Subject: RE: CM/72/21/DOC Mistletoe Farm

Drainage Engineer

The Drainage Engineers have provided the following comments with reference to condition 10

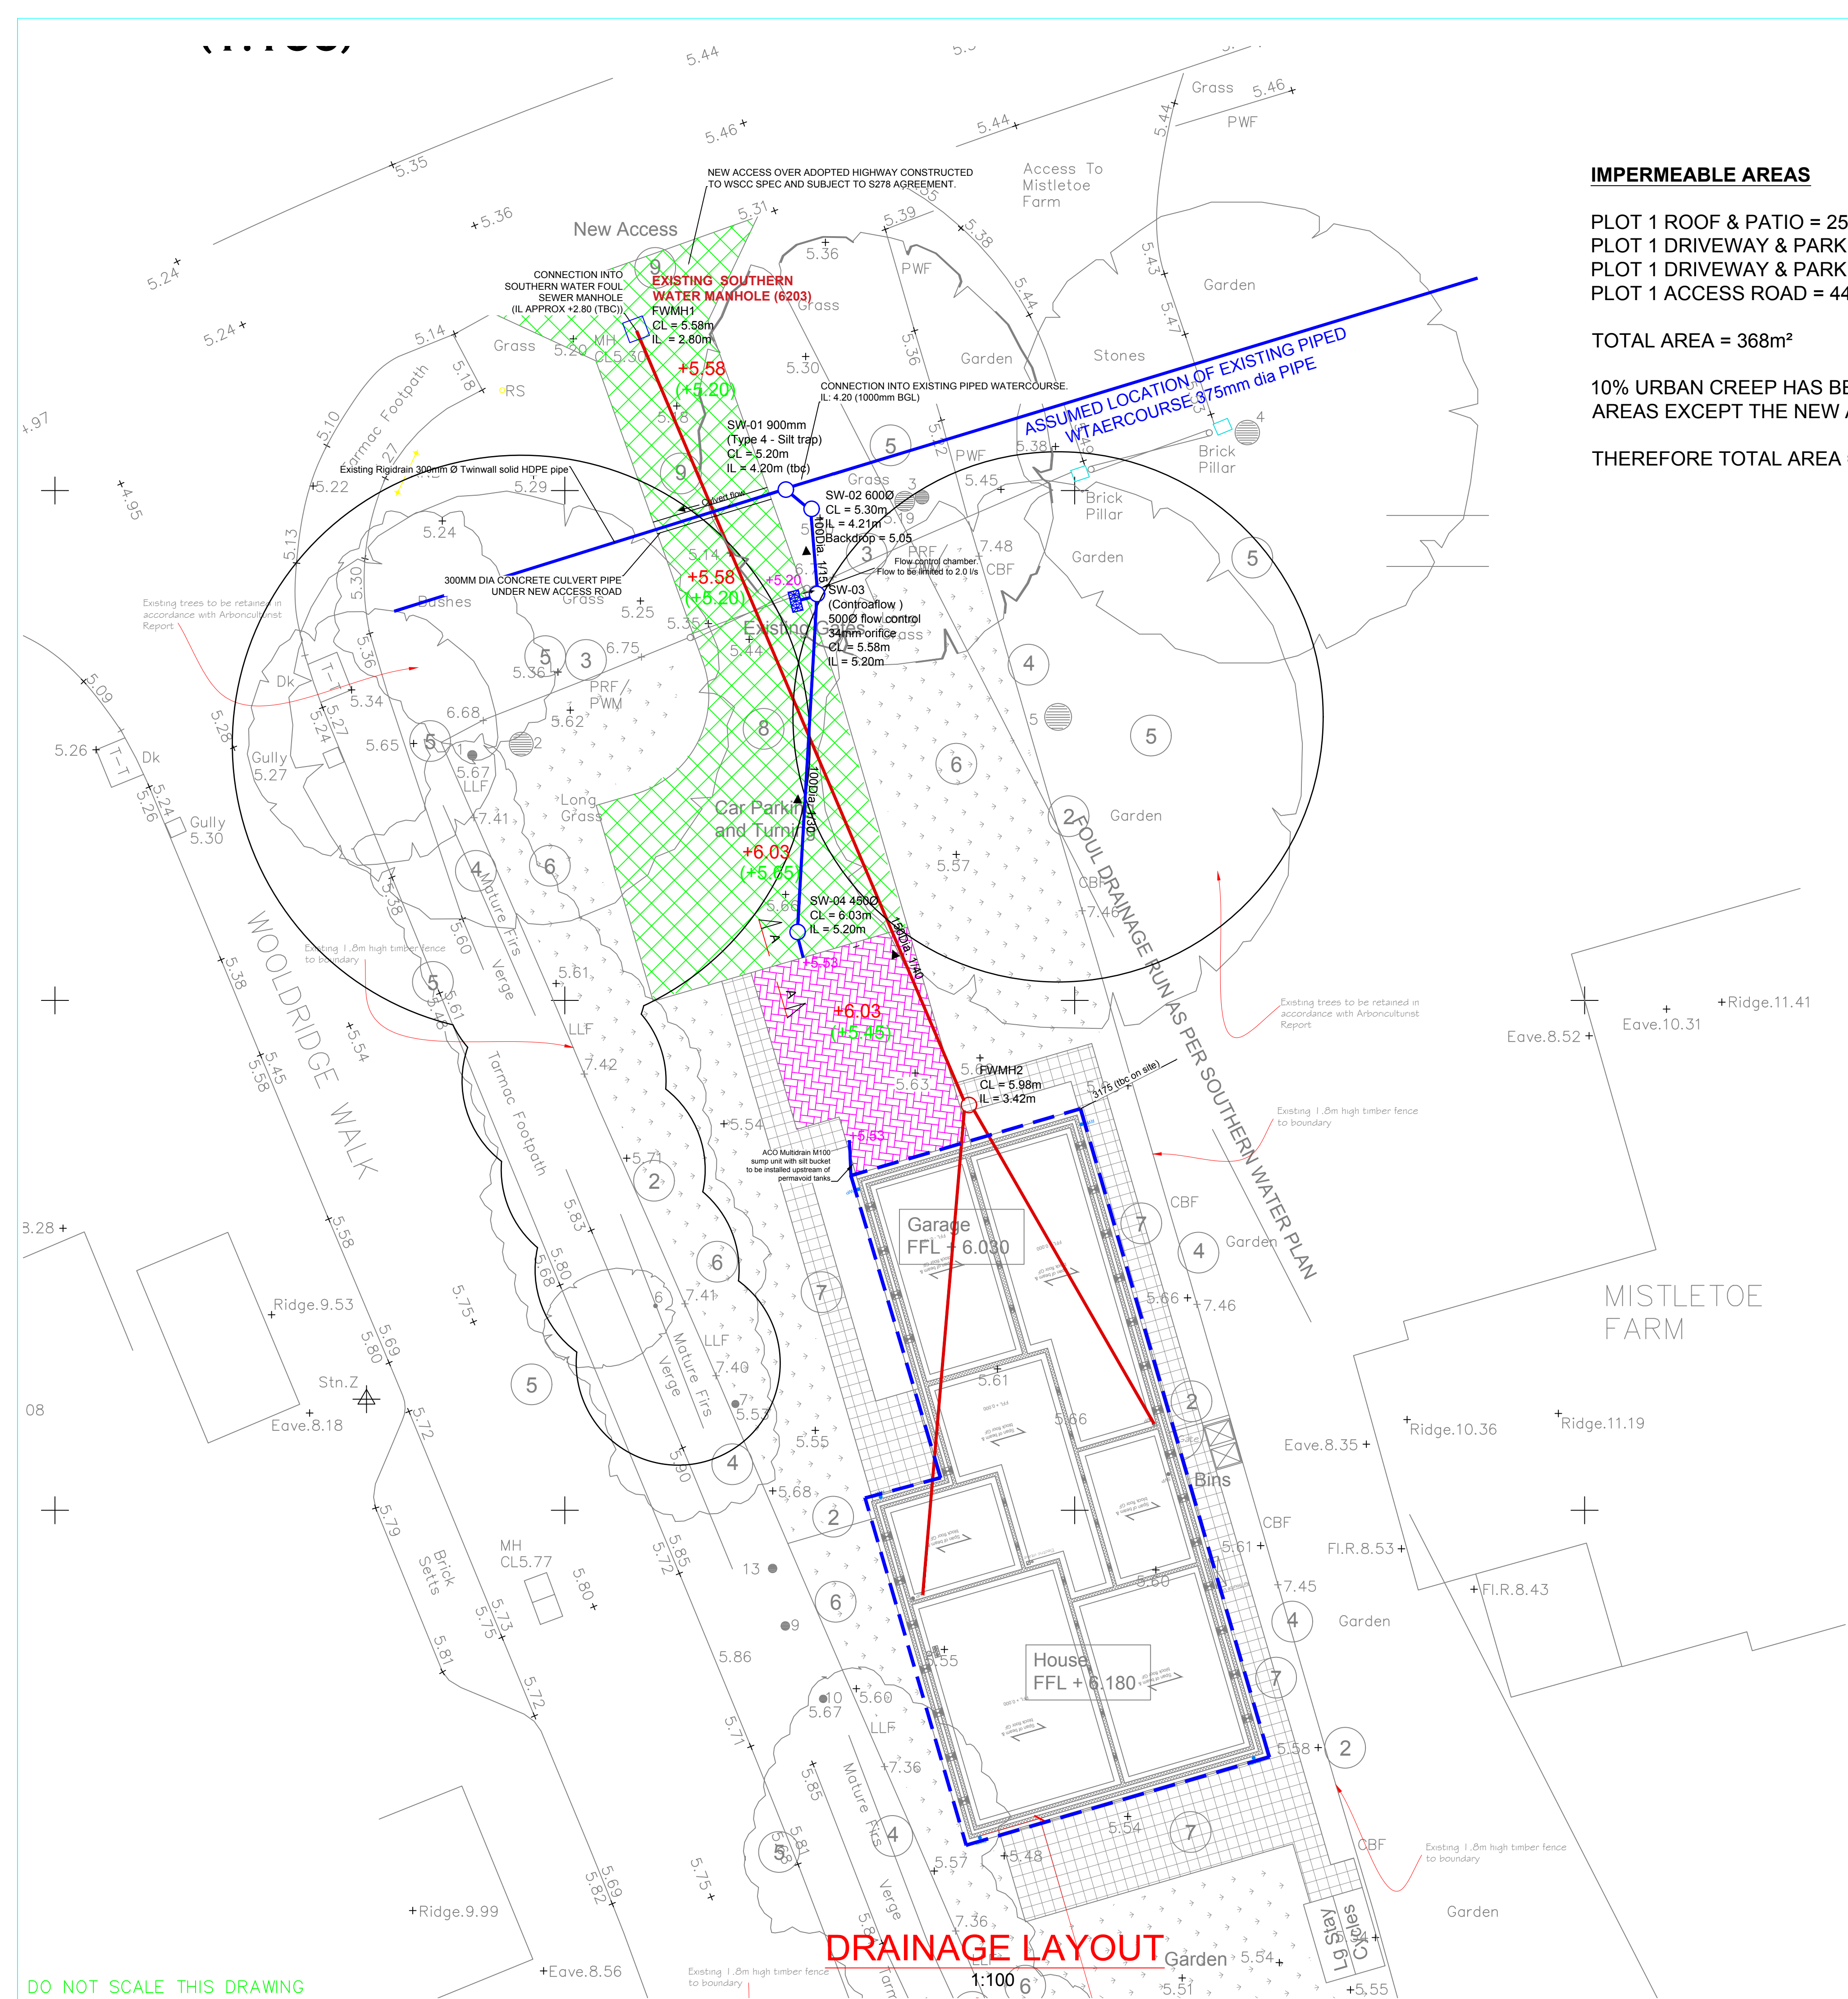
9. Please label all pipes with diameter and fall. **Updated** *No fall present between SW04 and SW03. But considerable fall between SW03 and SW02, please provide minimum fall between SW04 and SW03. Note ACO multidrain around building with no fall, is there no way to design the RWPs to provide only downpipes to the north of the building and remove this feature?*

11. Calculations do not demonstrate the required head specification for the hydrobrake. **Opted for Controflow with orifice** *See comment 9 above which may result in change to SW03 invert level. Please provide Controflow data to evidence orifice size and level are suitable.*

(SECTION A-A) - SECTION THROUGH JUNCTION BETWEEN PERMEABLE ACCESS ROAD / DRIVEWAY AREAS (WITHIN RPA) AND PERMEABLE DRIVEWAY WITH PERMAVOID SUB-BASE REPLACEMENT ATTENUATION SYSTEM
SCALE 1: 15

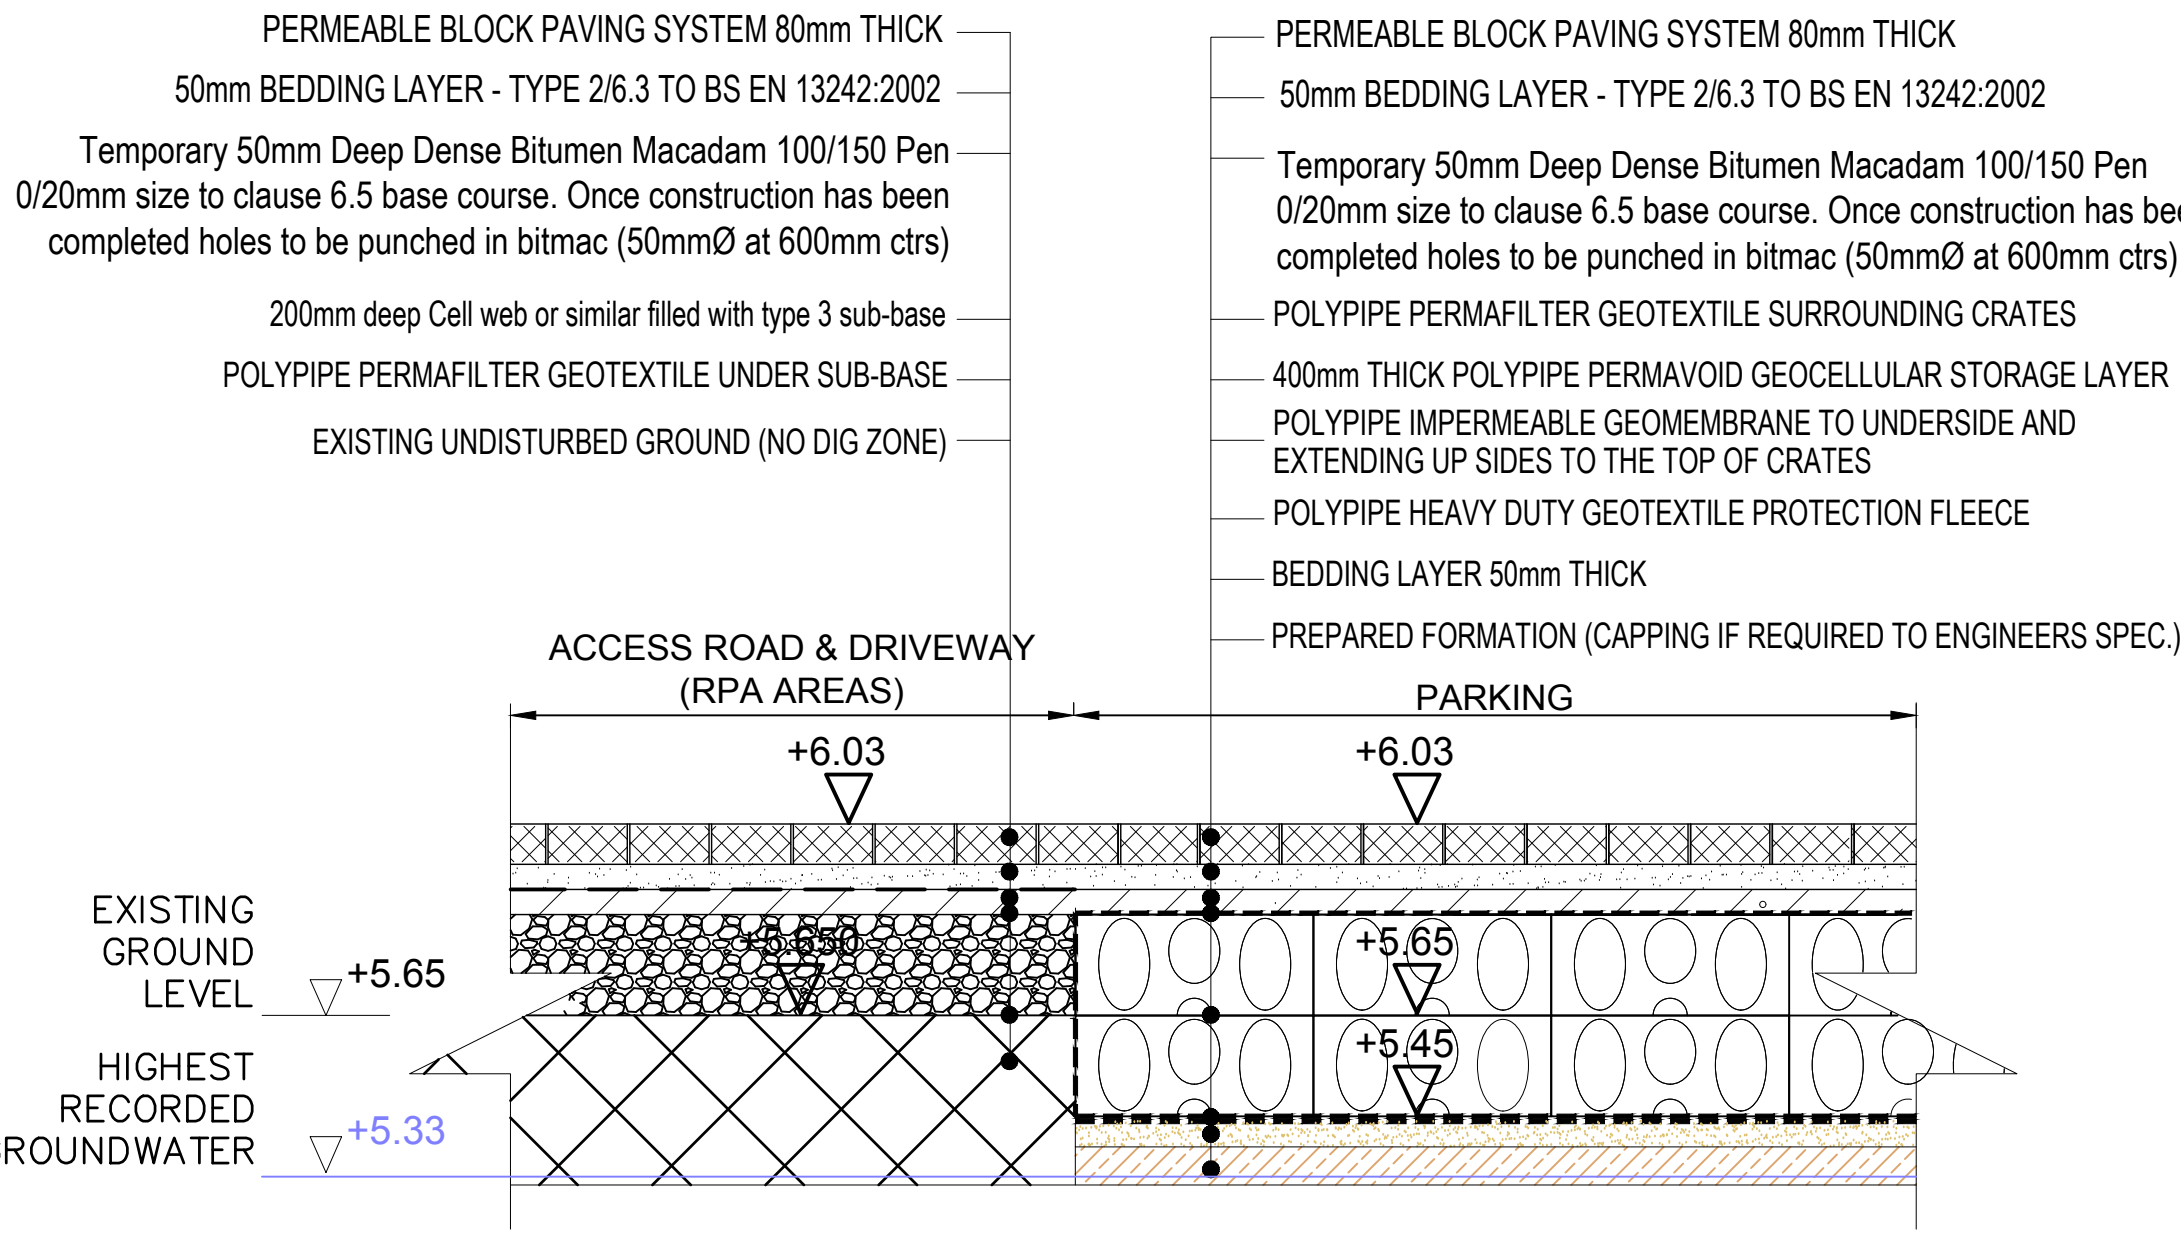
2. Section A-A states a highest recorded groundwater level of 5.33m AOD. This is 700mm below ground level, which is significantly lower than adjacent sites. Please provide winter groundwater monitoring results. **5.33 AOD is the correct level of the highest recorded groundwater, due to no dig areas within RPA's then we have raised our road levels by 380mm. Existing ground level is marked on the section & drawing. The groundwater monitoring results show shallowest groundwater at 0.32mbgl at WS1, although not directly clear in comments it appears that this figure has been used in design. Point closed.**

**TYPICAL DETAIL SUMP MANHOLE TYPE 'A'
COVER LEVEL TO SOFFIT OF PIPE <1.500M**
SCALE 1:20

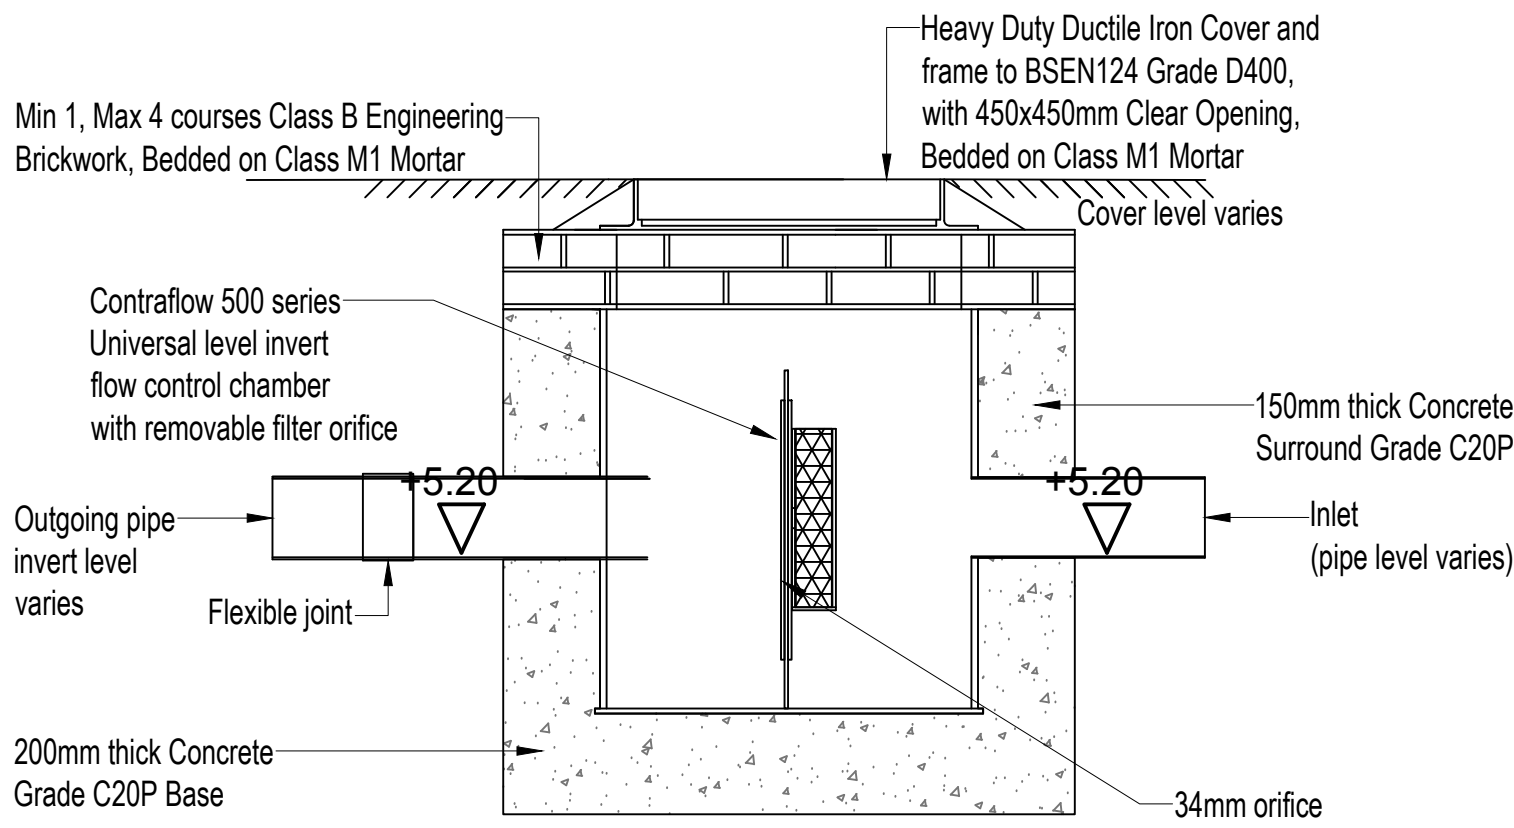
10. Please provide construction detail drawings of catchpits, pipe bed and surround, and hydrobrake. **Updated** *Catchpit detail is poor, e.g. benching should not be shown at pipe level, you are implying that the chamber extends below the internal base rather than there being a sump. Sump depth shown to base of in situ concrete foundation, please correct.*
